John Janusson and Betty Yee
7218 78th Avenue Southeast
Mercer Island, WA 98040

Reference: SUB23-003 – Public Comment Response
Apex Job No. 35887

Dear John Janusson and Betty Yee:

# PRELIMINARY SITE PLAN

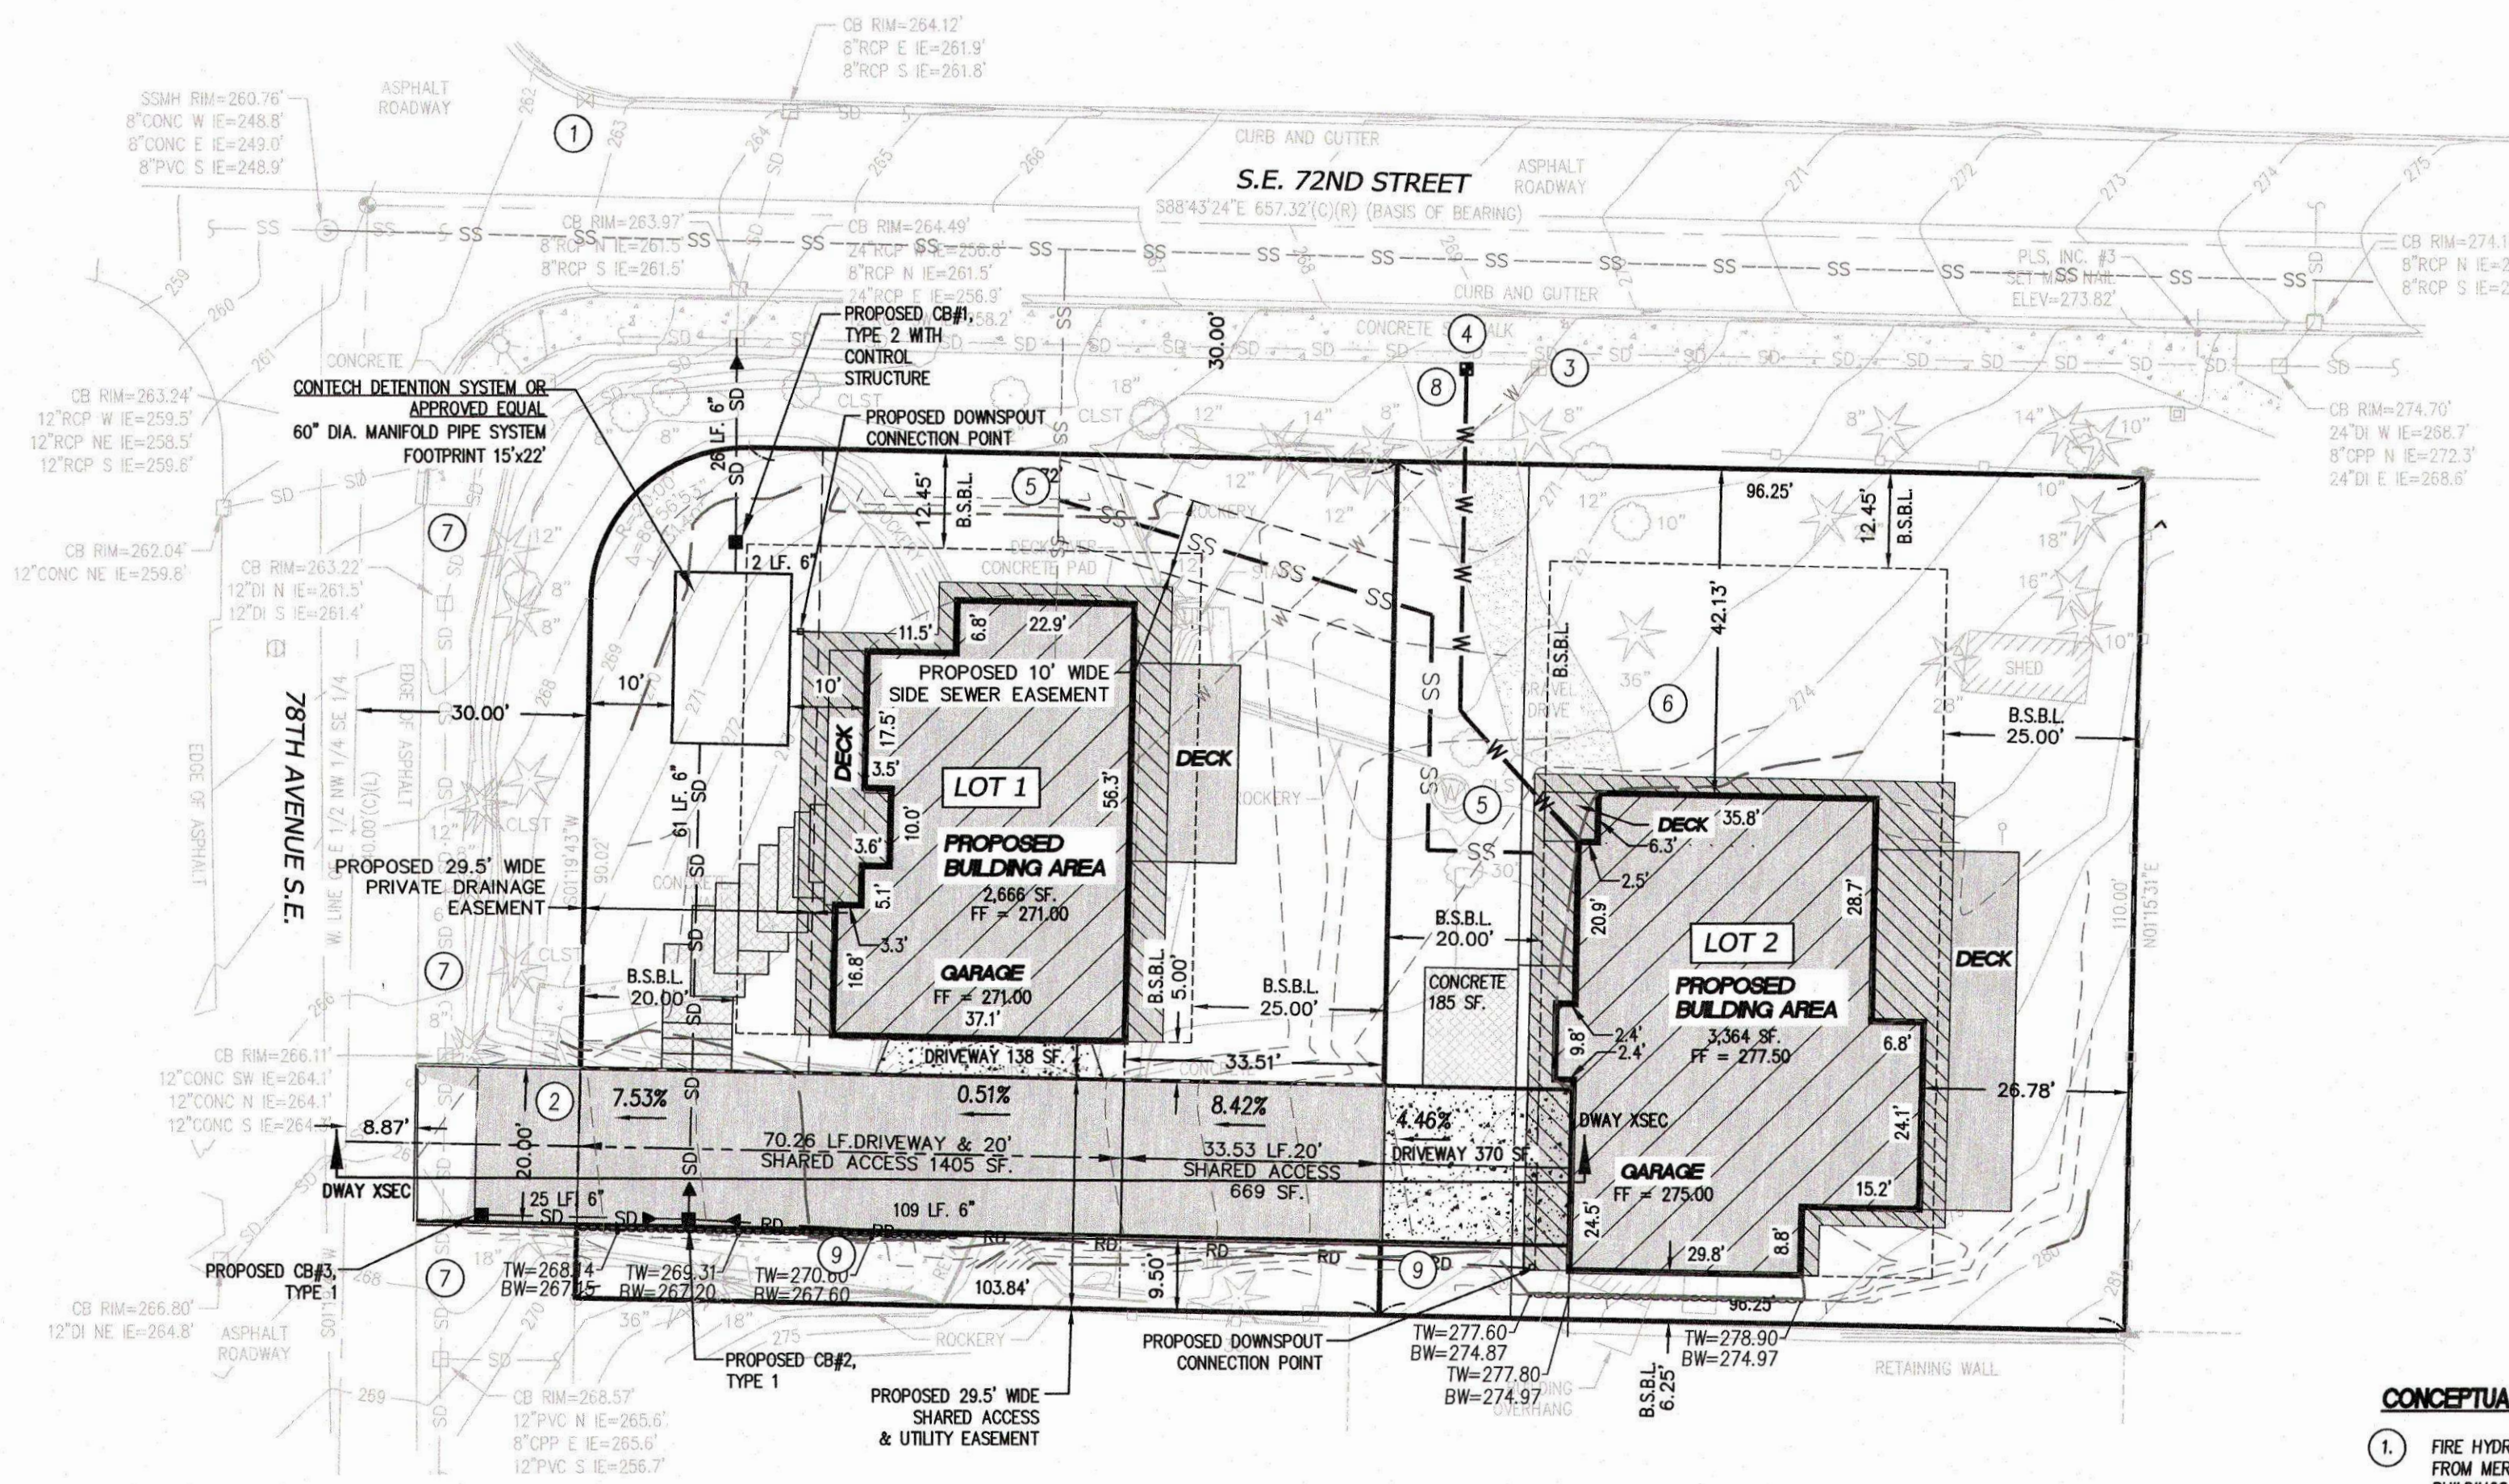
1. Per the plan the clearance from the building and our property line is 6.25 feet, and there are statements in the tree retention plans that state the lot 2 house will be moved even closer to our property for tree clearance reasons. What is the minimum clearance allowed by code?

Refer to the response from 5ft2 Studio submitted separately with this application package.

# CONCEPTUAL GRADING & UTILITY PLAN

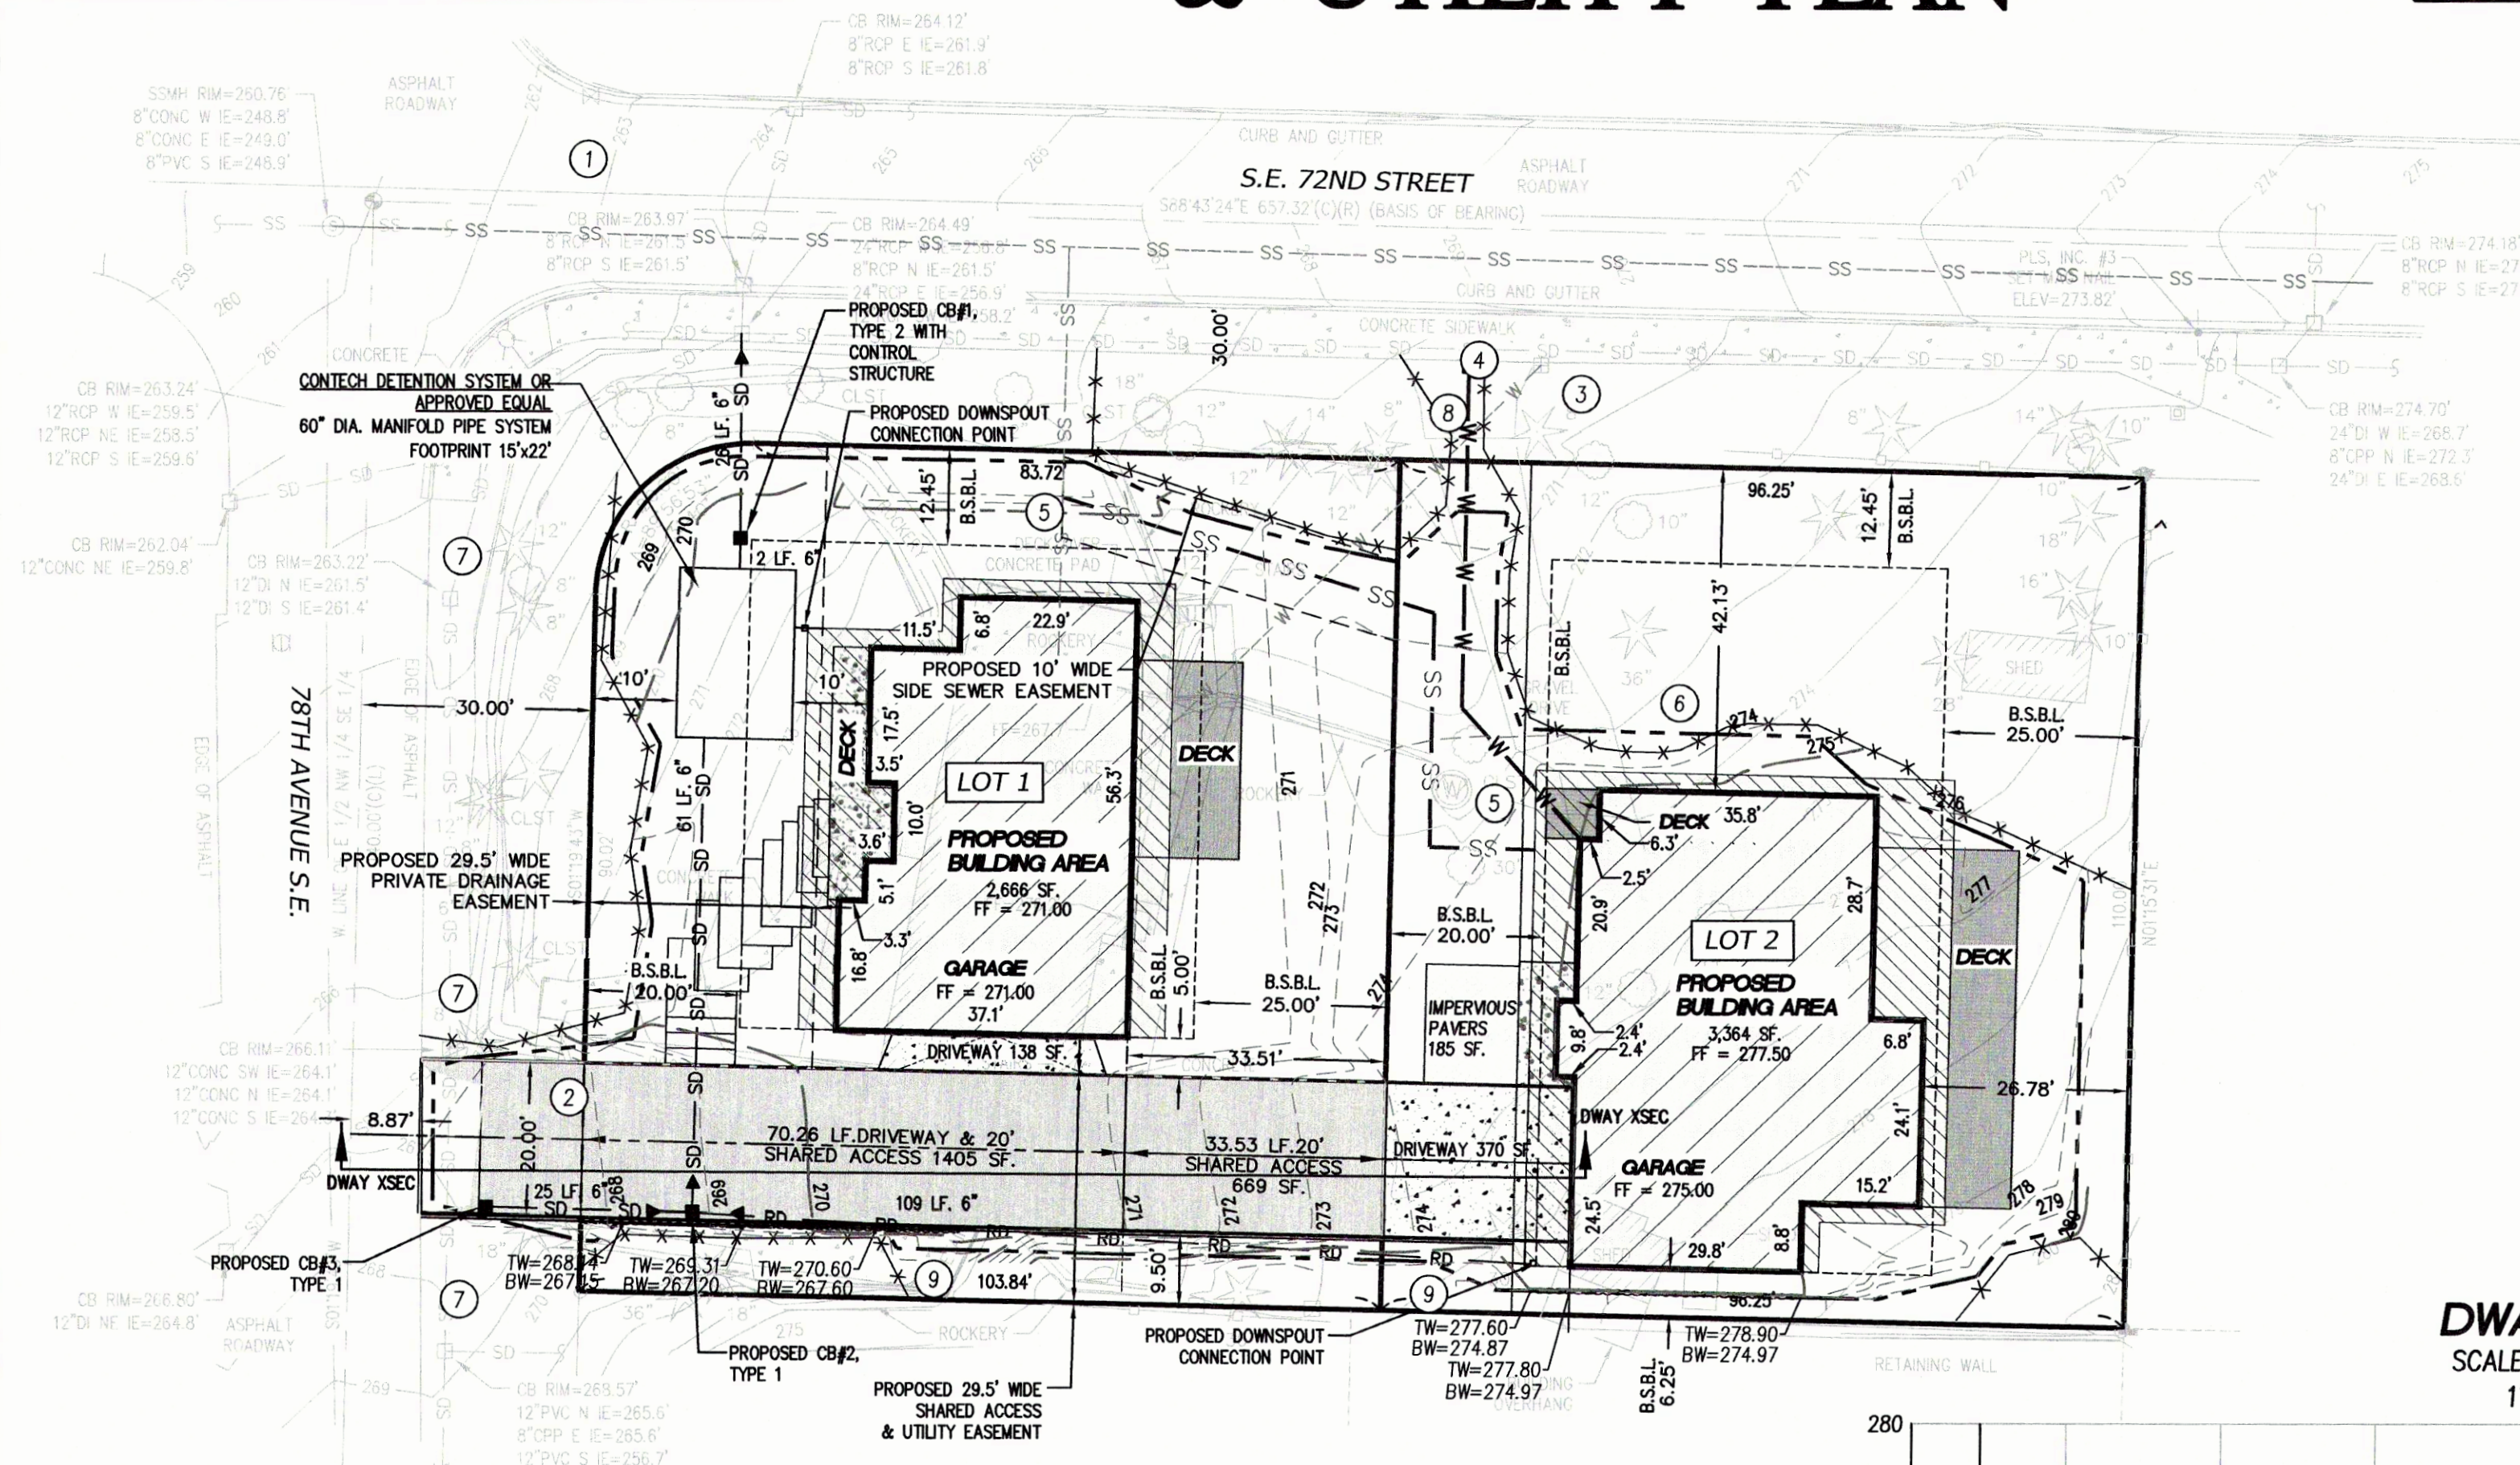
2. The drawing shows a "retaining wall" between the lot 2 house and our property line. Our property line features a retaining wall of our own. In short - this plan states the in the 6.25 feet between our property line/retaining wall and the new house there will be another retaining wall.

Removing the proposed retaining wall would create an unstable slope between the pad on Lot 2 and adjacent property line with a grade up to 65%. Furthermore, grading down toward the pad from the property line would not allow for adequate drainage from the pad. Emergency vehicle access requirements do not allow the proposed pad to be raised to a height at which a stable slope between the pad and property line and proper drainage from the pad could be achieved without a retaining wall. Therefore, the proposed retaining wall is required for pedestrian, vehicular and environmental safety as well as adequate grading and stormwater design. The proposed wall should not affect the stability of the slope or the approximately 2-foot-high landscaping wall on your side of the lot line.

The height of the proposed wall, measured from the top of the retaining wall to the finished grade, does not exceed 4 feet. This is less than the maximum allowed retaining wall height specified in the Mercer Island Code Section 19.02.050-D.
